**SUBJECT: SFD2006-0003
SINGLE FAMILY DWELLING**

Here are the results of all Inspections located at **230 WHIT CT:**

FIRST FLOOR FRAMING

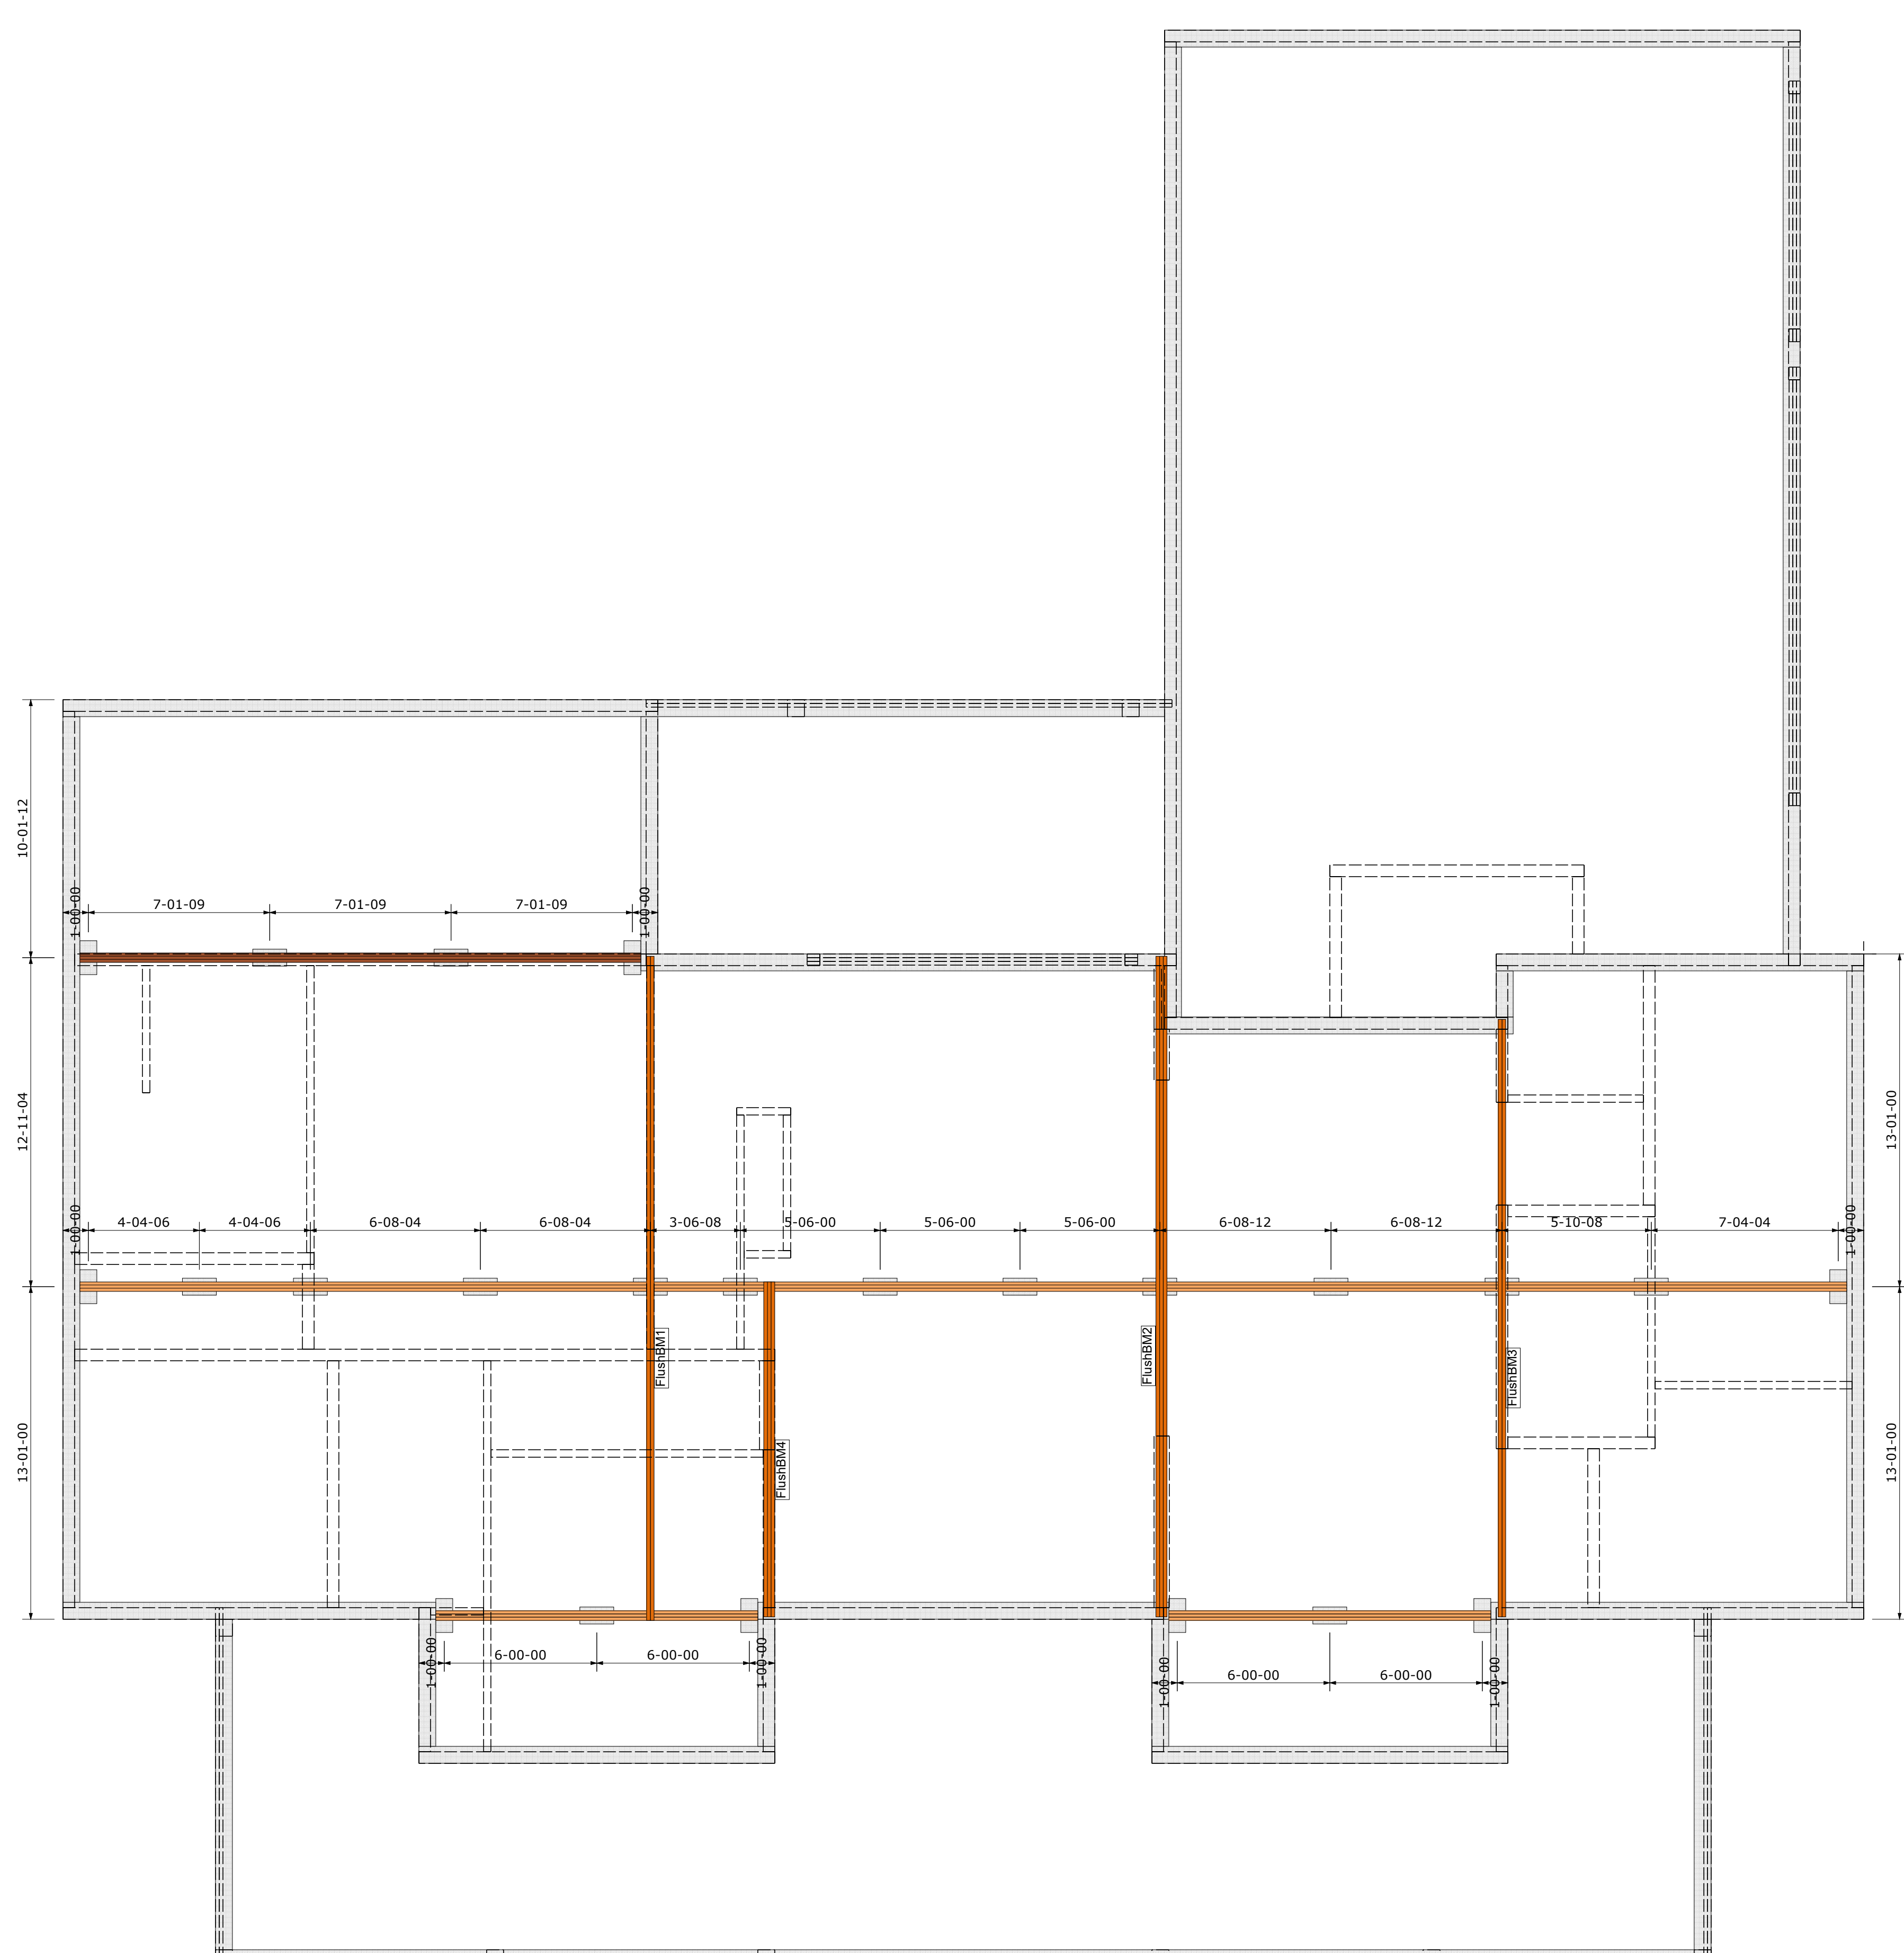
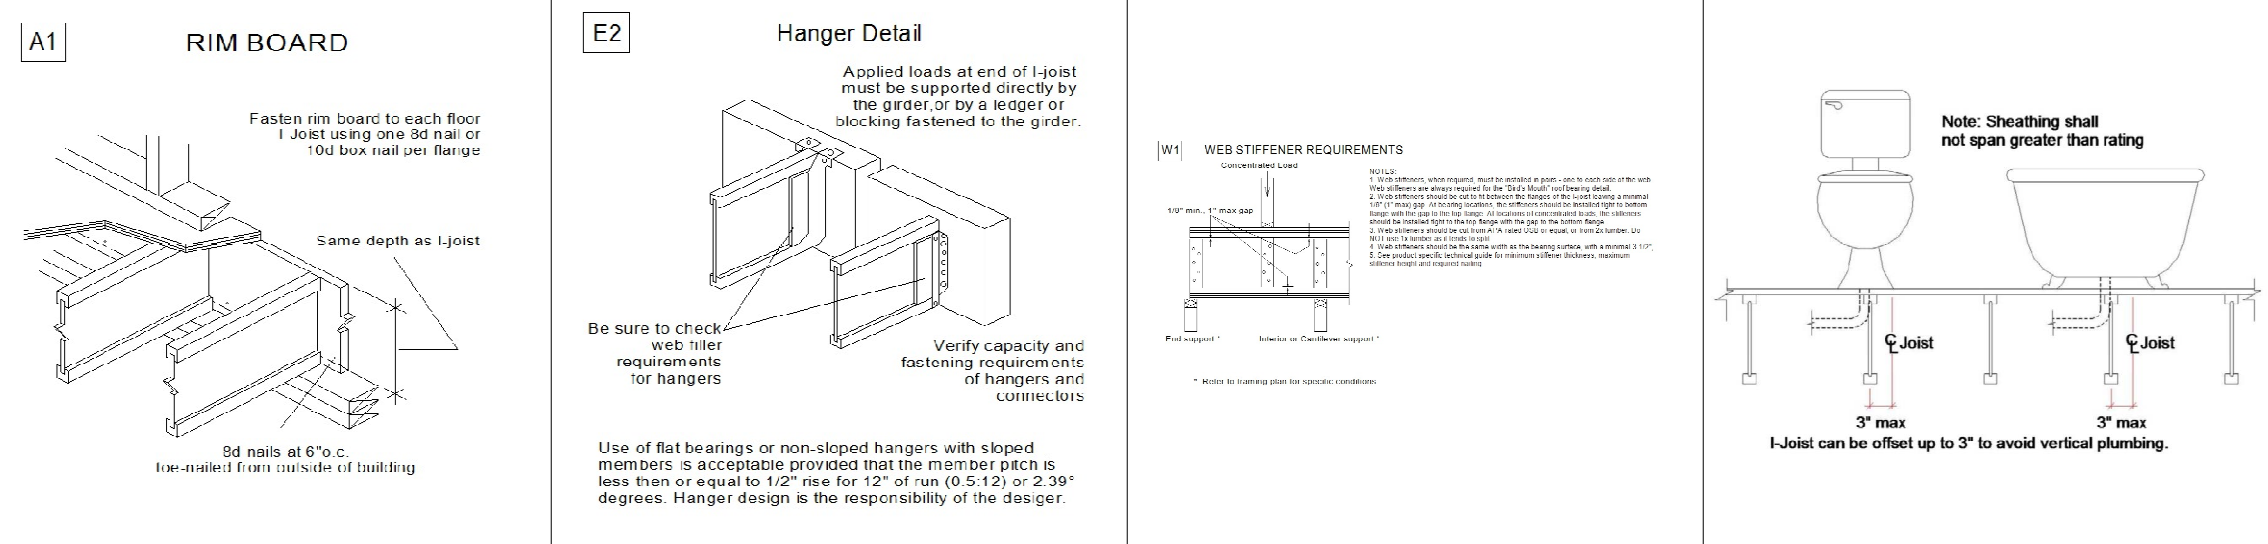
Look at I-joint layout for double in kitchen. I-joint not installed per plan.
